Arun District Council
Arun Civic Centre
Maltravers Road
Littlehampton
West Sussex BN17 5LF
Planning & Building Control General Enquiries
Tel: (01903) 737756 Fax: (01903) 730442
Dx: 57406 Littlehampton
Minicom: 01903 732765
e-mail: planning@arun.gov.uk
website: www.arun.gov.uk/planning

Application No: A/3/21/PL
Site Address: Pound Place Roundstone Lane Angmering BN16 4AL
Description of works: Erection of a 74-bed care home (C2 residential institution) with car parking, landscaped gardens & access from Roundstone Lane. (resubmission following A/9/19/PL). This site is in CIL Zone 2 (Zero Rated) as other development.

Thank you for your internet representation made on 25th February 2021 which has been recorded as an objection with the comments as follows:

Drawing Site Layout
General Arrangement

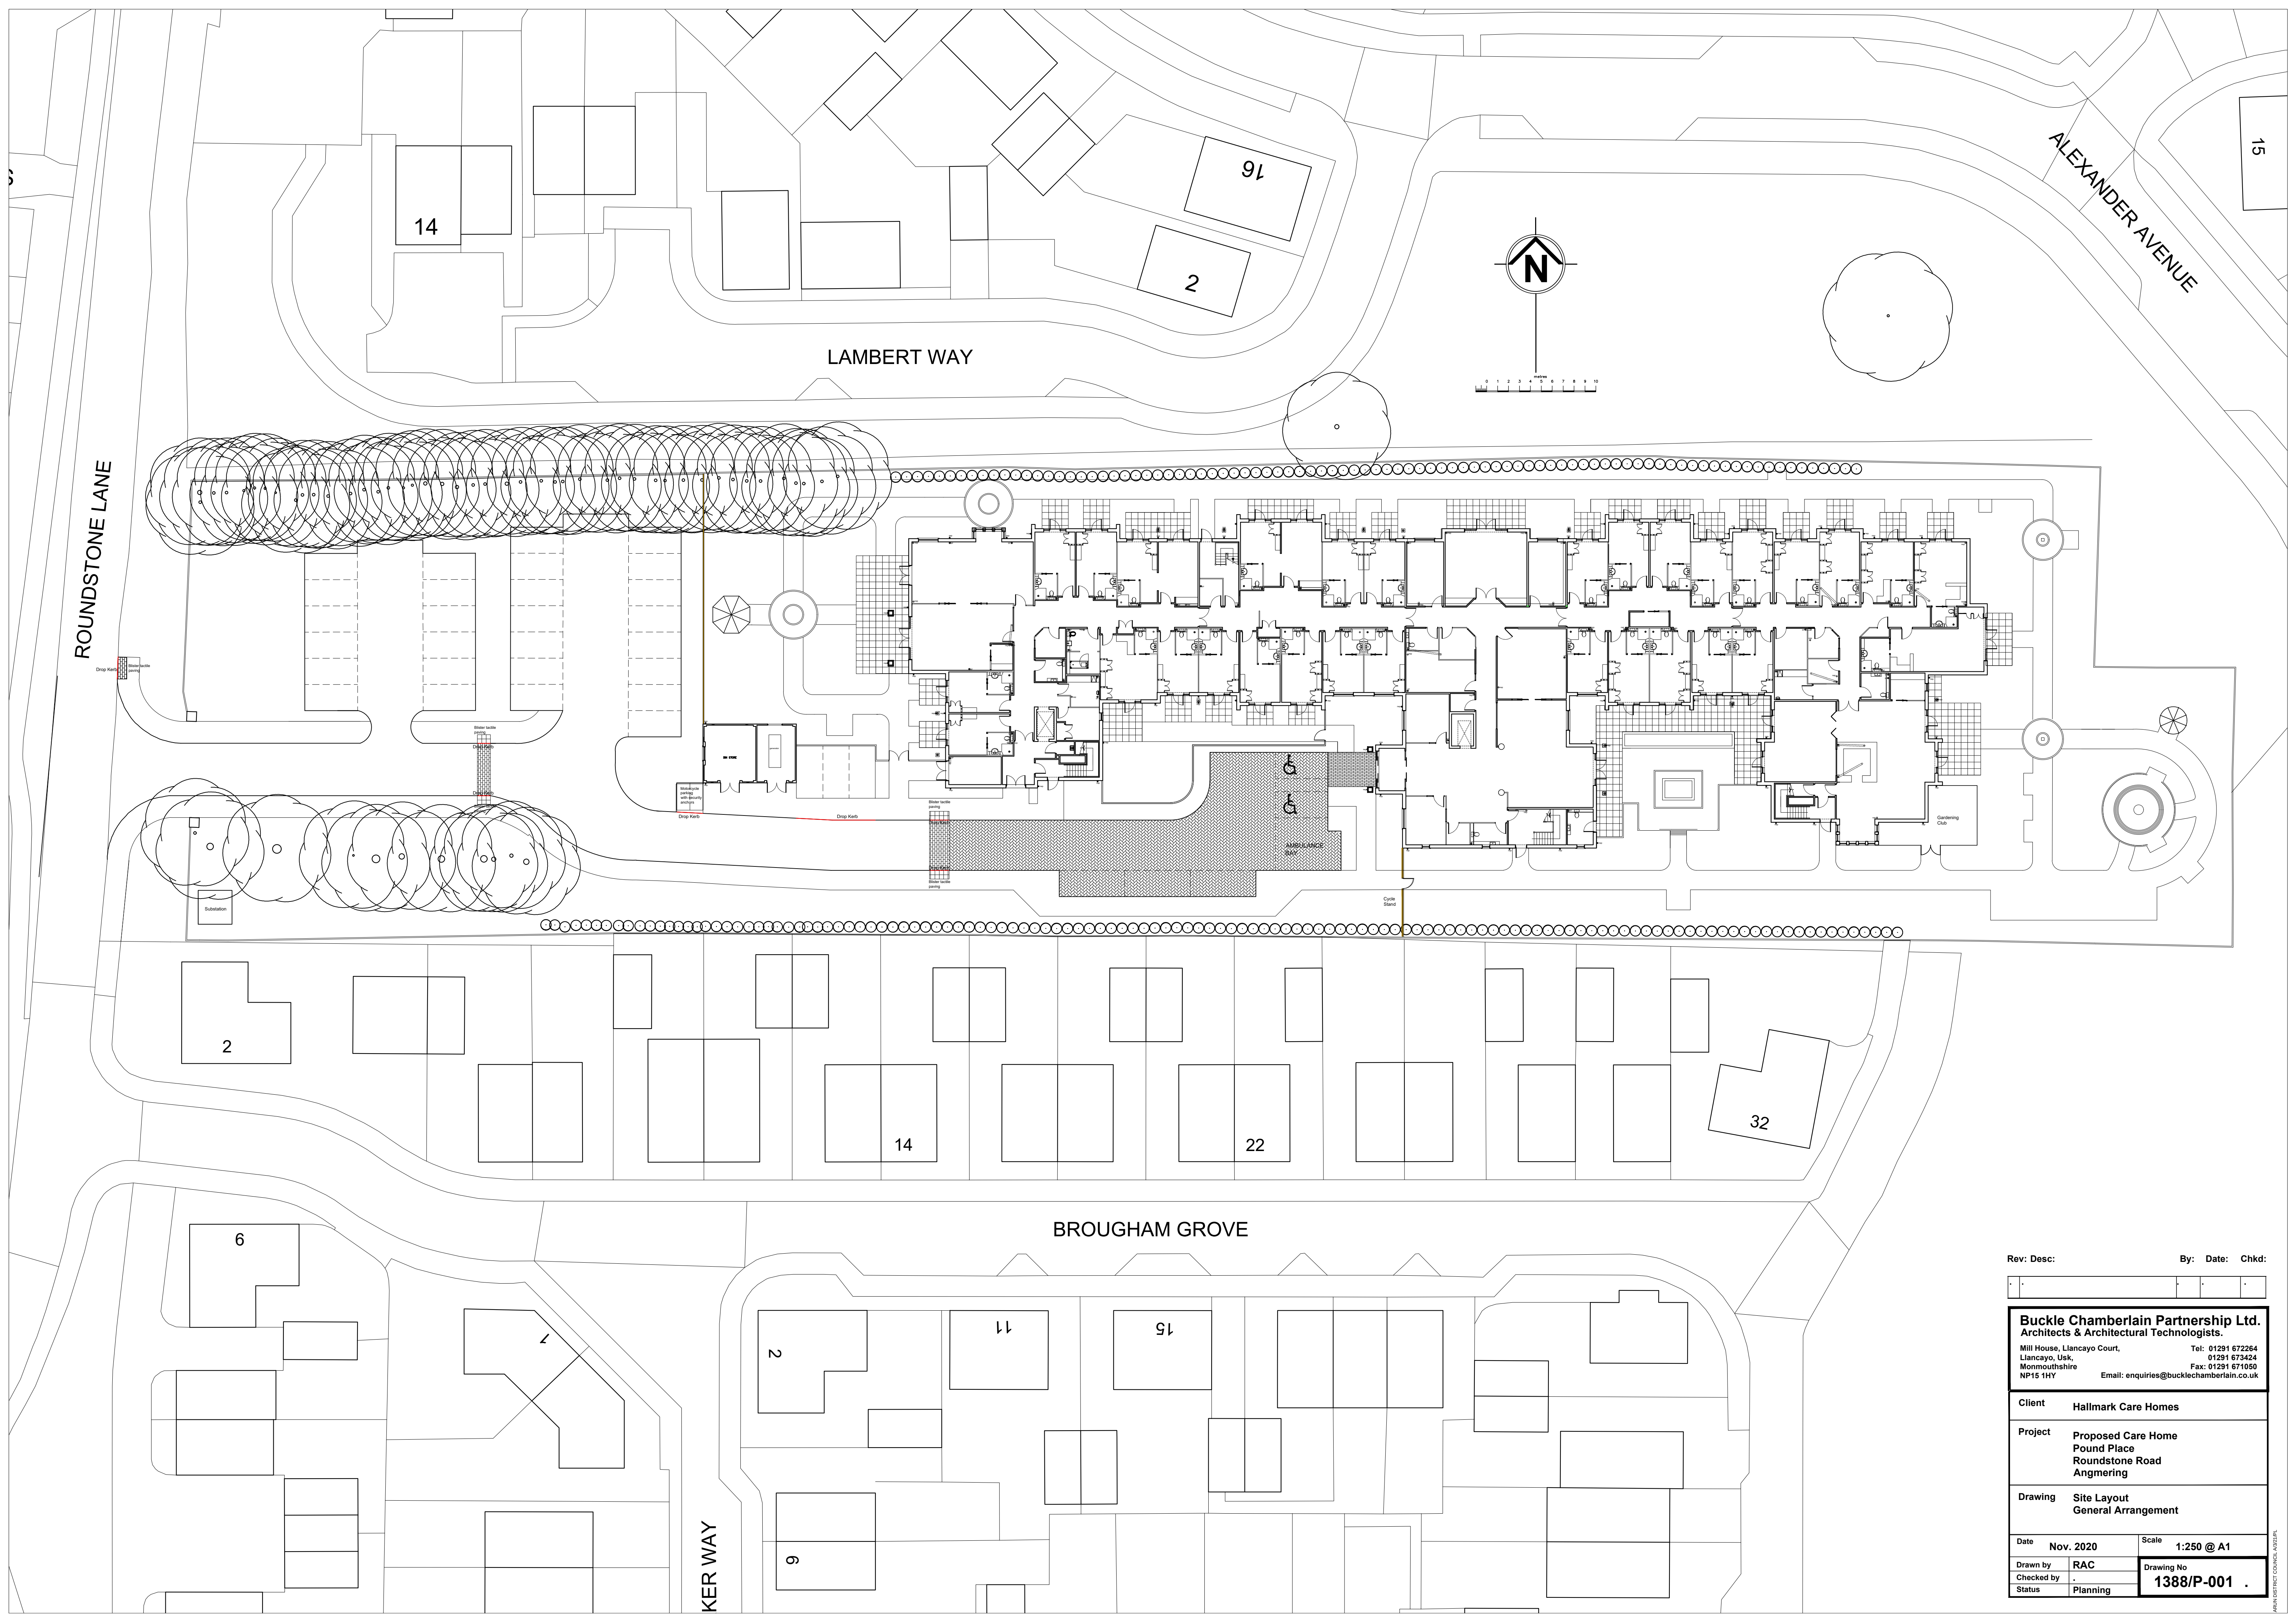
1) There are significant elements missing from the submission which were part of the previous application. This includes boundary treatment and planting. In its current guise the application will provide no assurance that tree replacement and visual shielding provided by the previous conditions would need to be implemented.

SECOND FLOOR PLAN

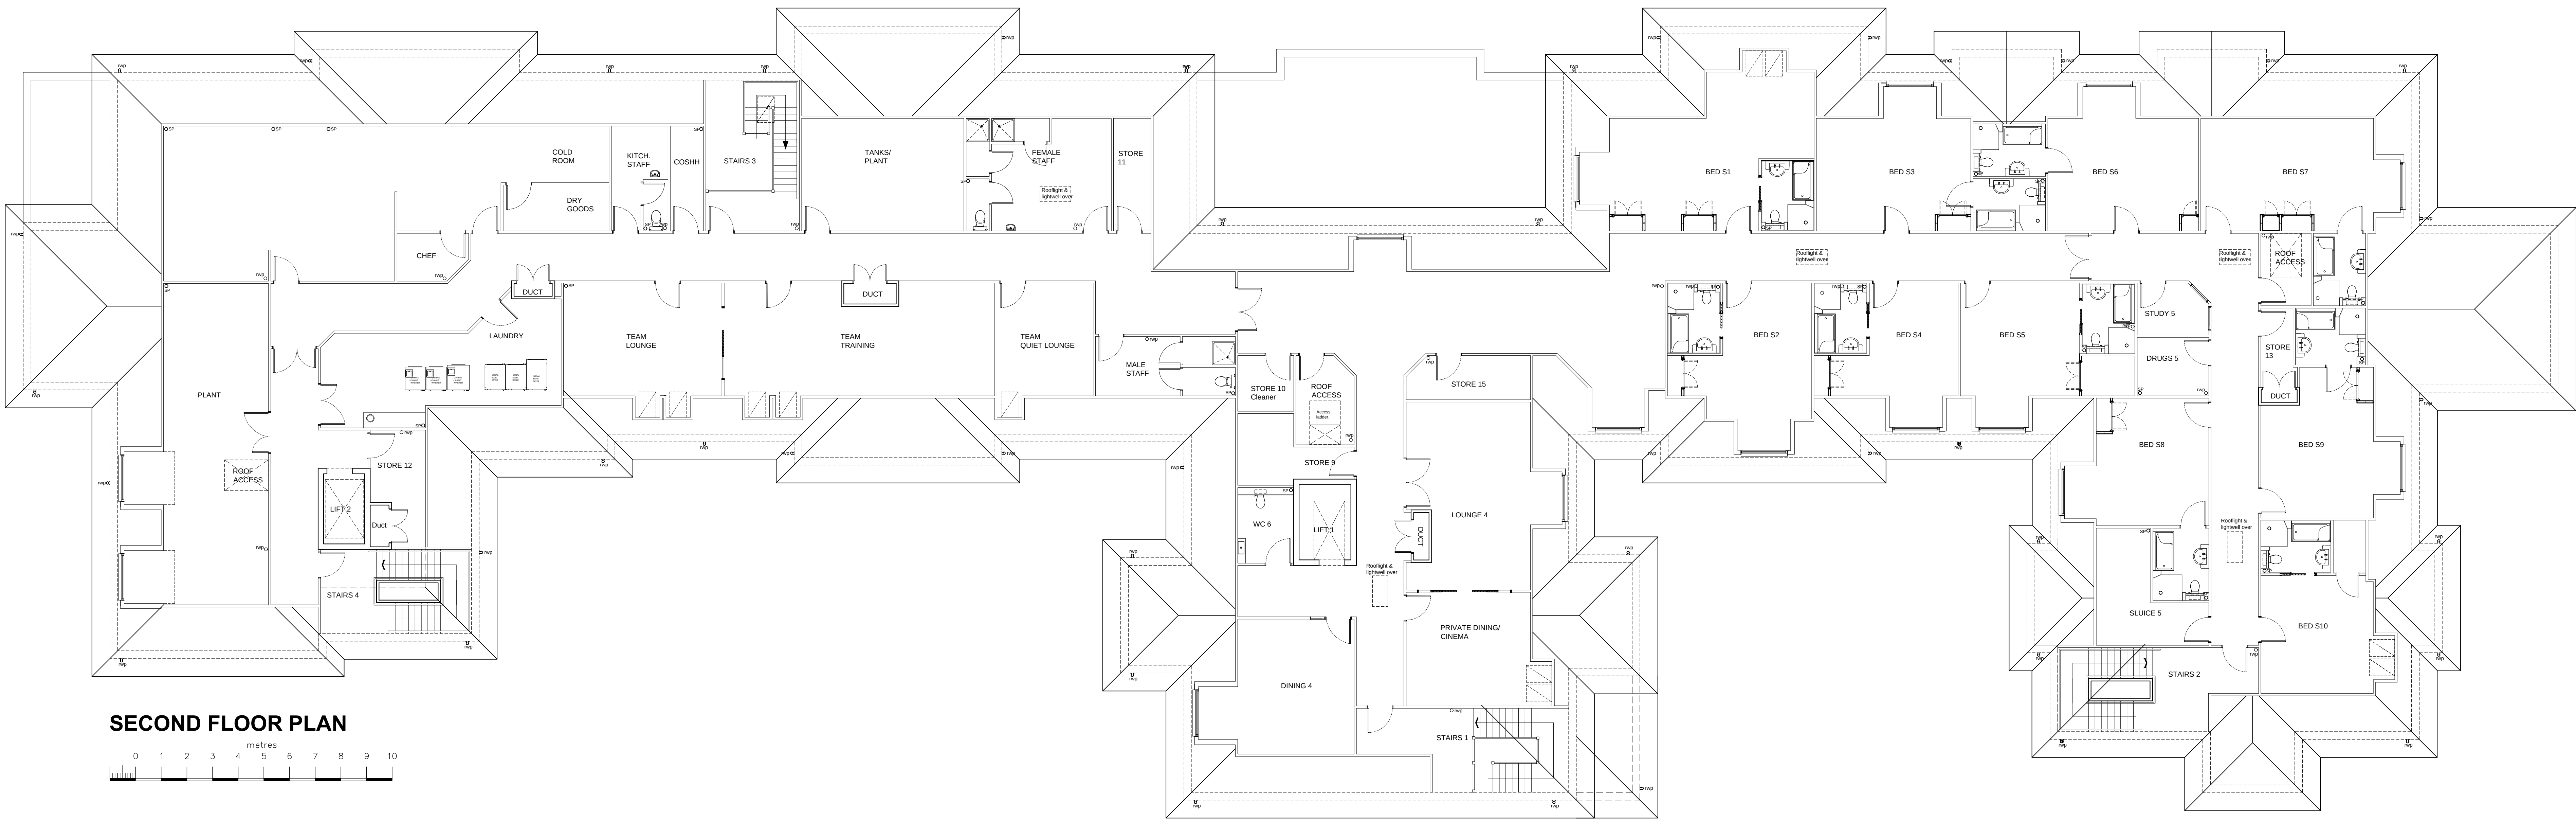
2) The 2nd floor rooms approved under an amendment to a previous application for office use (5x8) are now planned as bedrooms (24x7). These have direct sight lines into bedrooms and living areas of adjacent properties at less than 30m in some instances. The application has not demonstrated that this will be mitigated with visual shielding.
